From:
Sent: 03 June 2026 02:09
To: DC Admin
Subject: 2026/90232 - New Mills, Brougham Road, Marsden, HD7 6AZ

I am writing in my capacity as a former councillor for Colne Valley ward providing support for the application, while also providing some comments regarding the development on how it could be strengthened and address the concerns of local residents.

**REDEVELOPMENT OF NEW MILLS.
 BROUGHAM ROAD, MARSDEN**
**PROPOSED HIGHWAY IMPROVEMENTS
 BROUGHAM ROAD EAST**

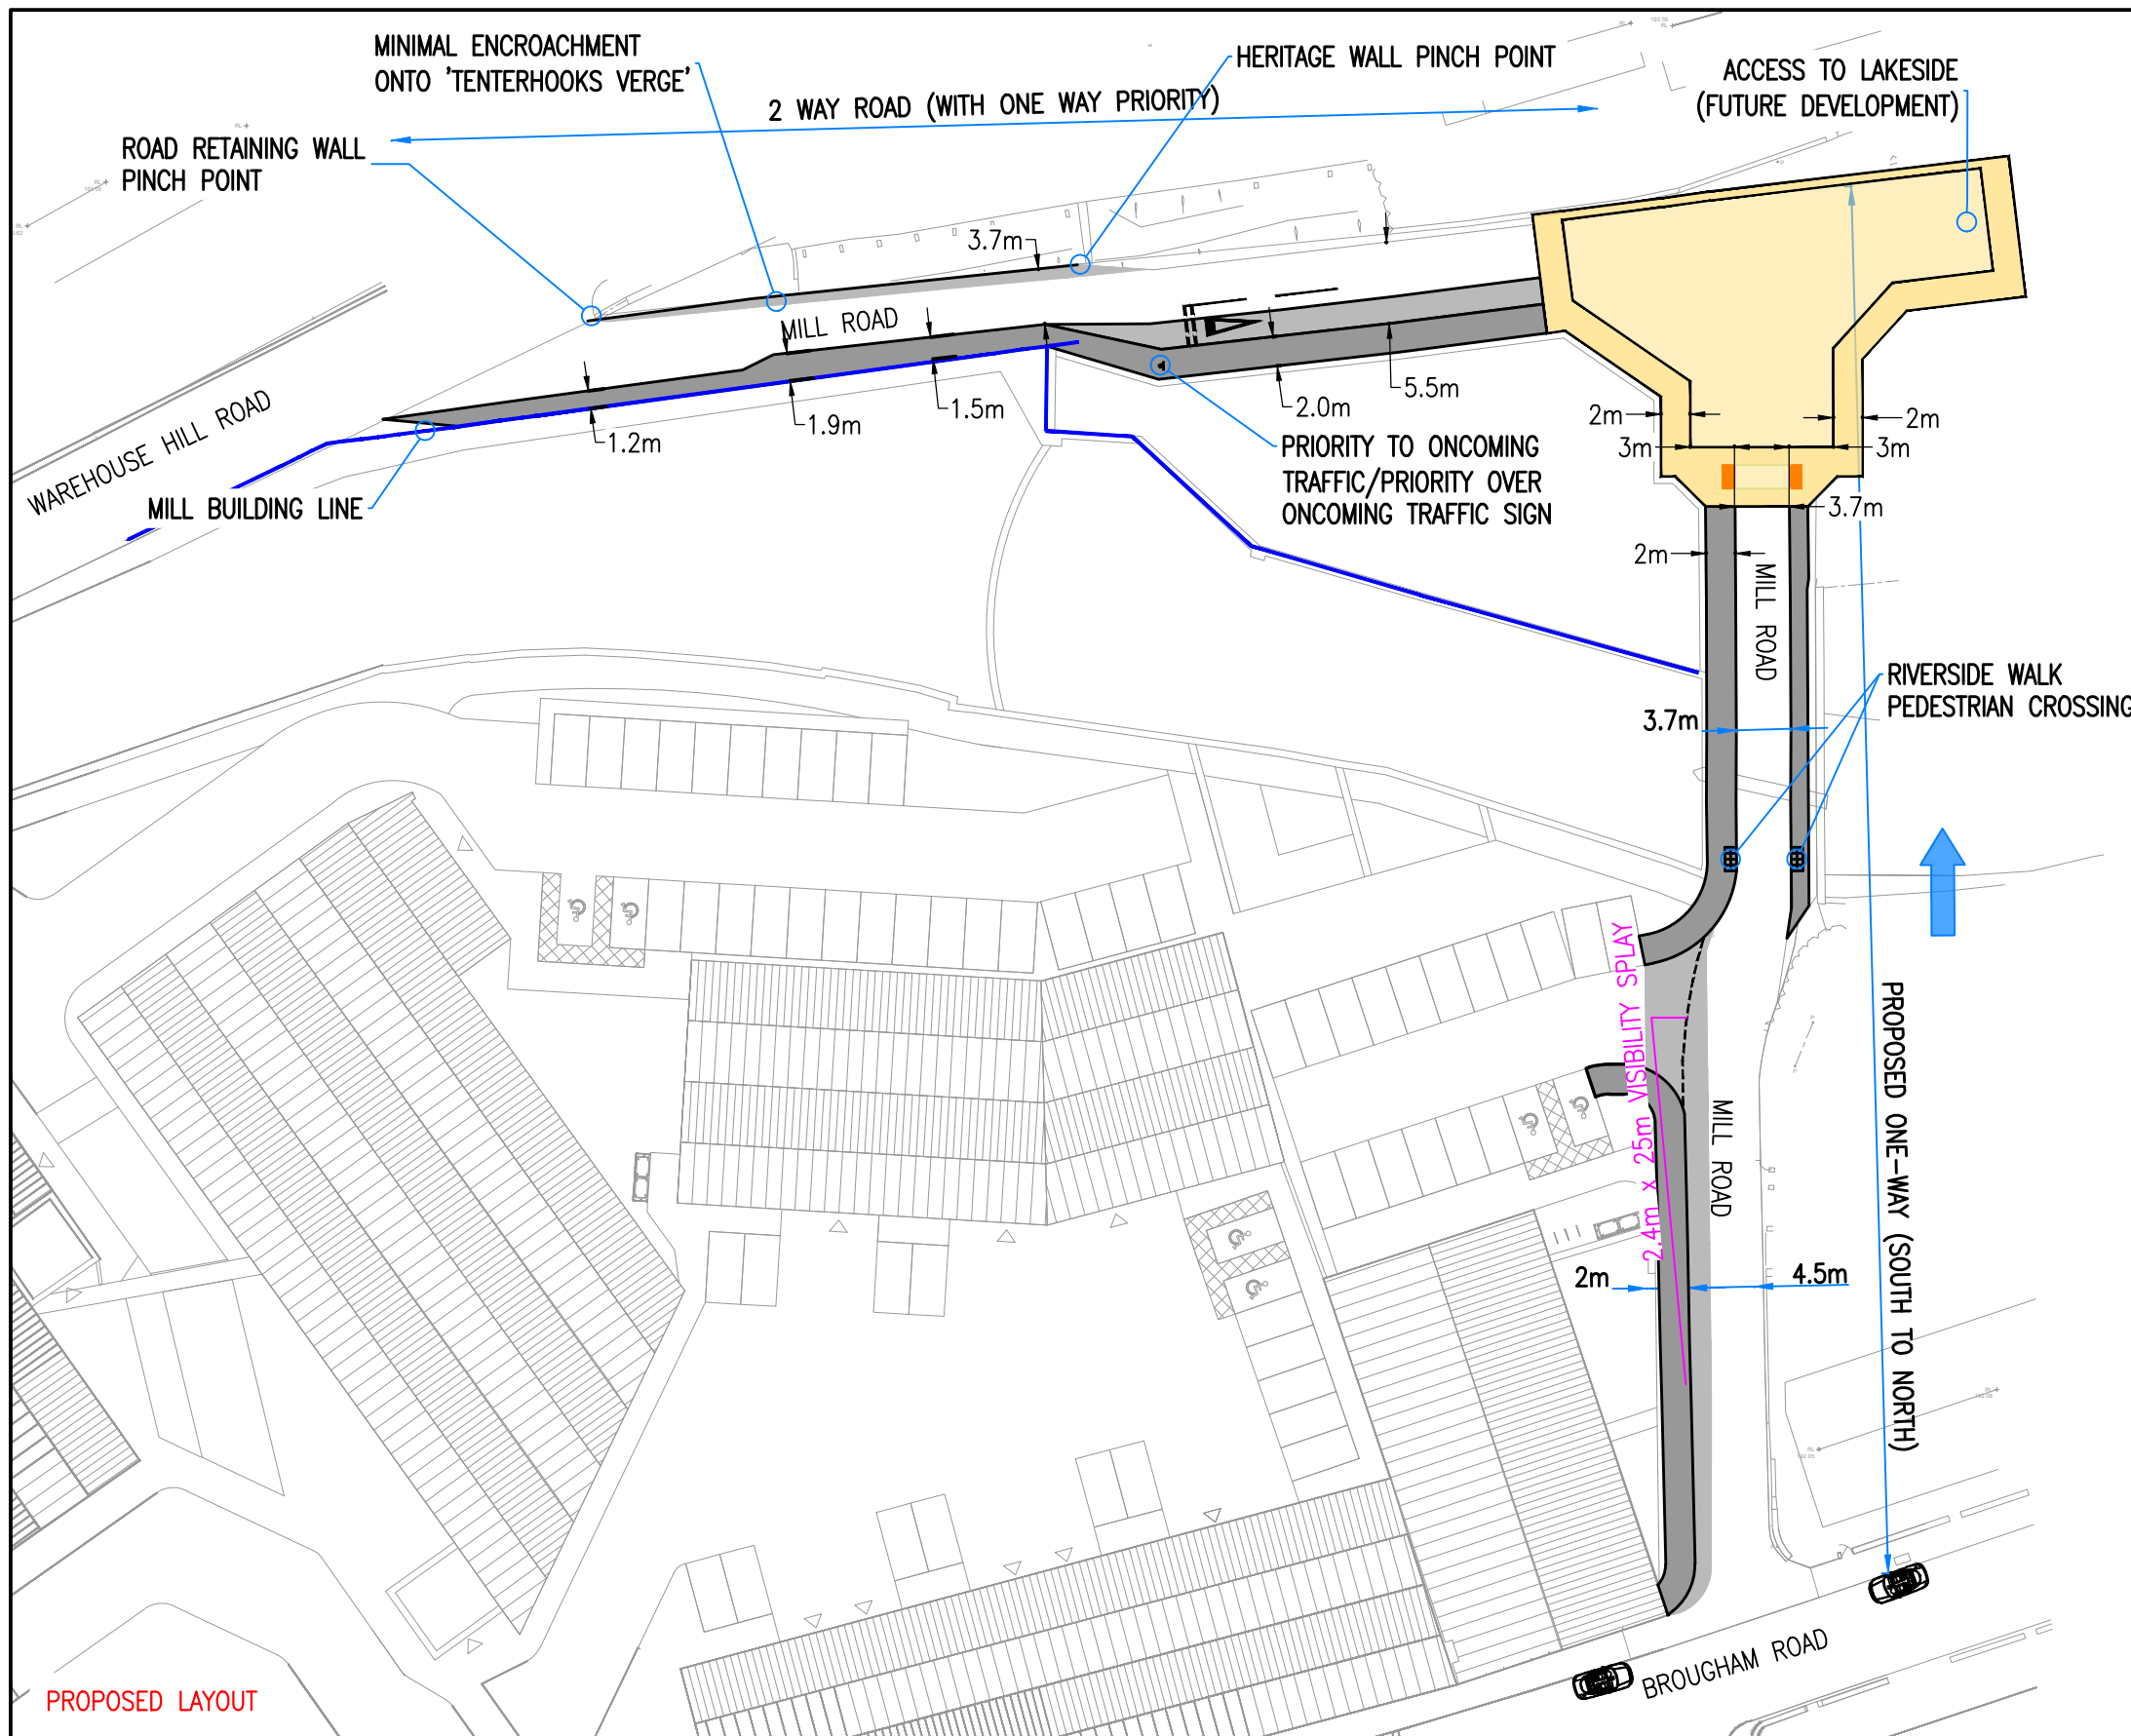
The development is also immediately opposite Marsden Infants School. Many residents have reported concerns with speeding, dangerous driving and inappropriate parking on Brougham Road which should be addressed as part of the scheme. Introducing traffic calming measures and a partial one way system would be welcome. The junction between Brougham Road and Crowther Bruce Mill Road is also currently dangerous, and it could be widened and visibility improved.

Staff and parents at Marsden Junior School have also expressed concern that the introduction of parking bays on Brougham Road may reduce the parking that is available to them. It may be prudent to use the vacant piece of land opposite the development owned by the developer as an overflow/school car park, which would also reduce pressure on Brougham Road. I appreciate that this lies outside of the development's red line boundary, but an arrangement could be found with the developer outside of the planning process.
